Subject: FW: WA/94/19/NMA, WA/95/19/DOC and WA/96/19/DOC - Land East of Tye Lane, Walberton EMAIL 1

Further to the submission of the revised landscape drawings attached, received from Laura Humphries-Linden Homes on 09/01/2020 and subsequently forwarded by yourself, I can confirm that the minor amends as now submitted regarding the landscape detail, **still propose** a scheme which is fitting for location and application and will form (given establishment allowance) a scheme which will be suitable and fit for purpose. The proposals have sought to largely re-distribute (with some minor additions) primarily the trees in locations along the golf netting and open space areas.

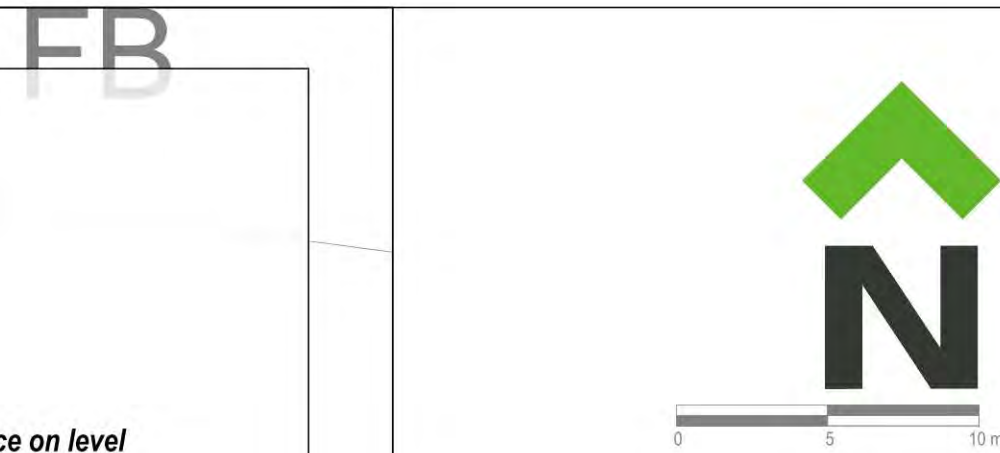
- In relation to Golf netting amendment, and the associated dwgs CSA/3823/107 Rev L, 101 Rev K, 102 Rev H, 103 Rev H, 108 Rev J, 109 Rev K, 110 Rev K, specifically tree locations and additions and the thicket mix to perimeter locations, I can confirm I have no further to add to my recommendation of 10/10/19 & 17/12/19 recommending **No Objection on landscape grounds for the amendment to approved landscape plans (Condition No 1) on application WA/94/19/NMA** following the grant of permission reference WA/95/18/RES.
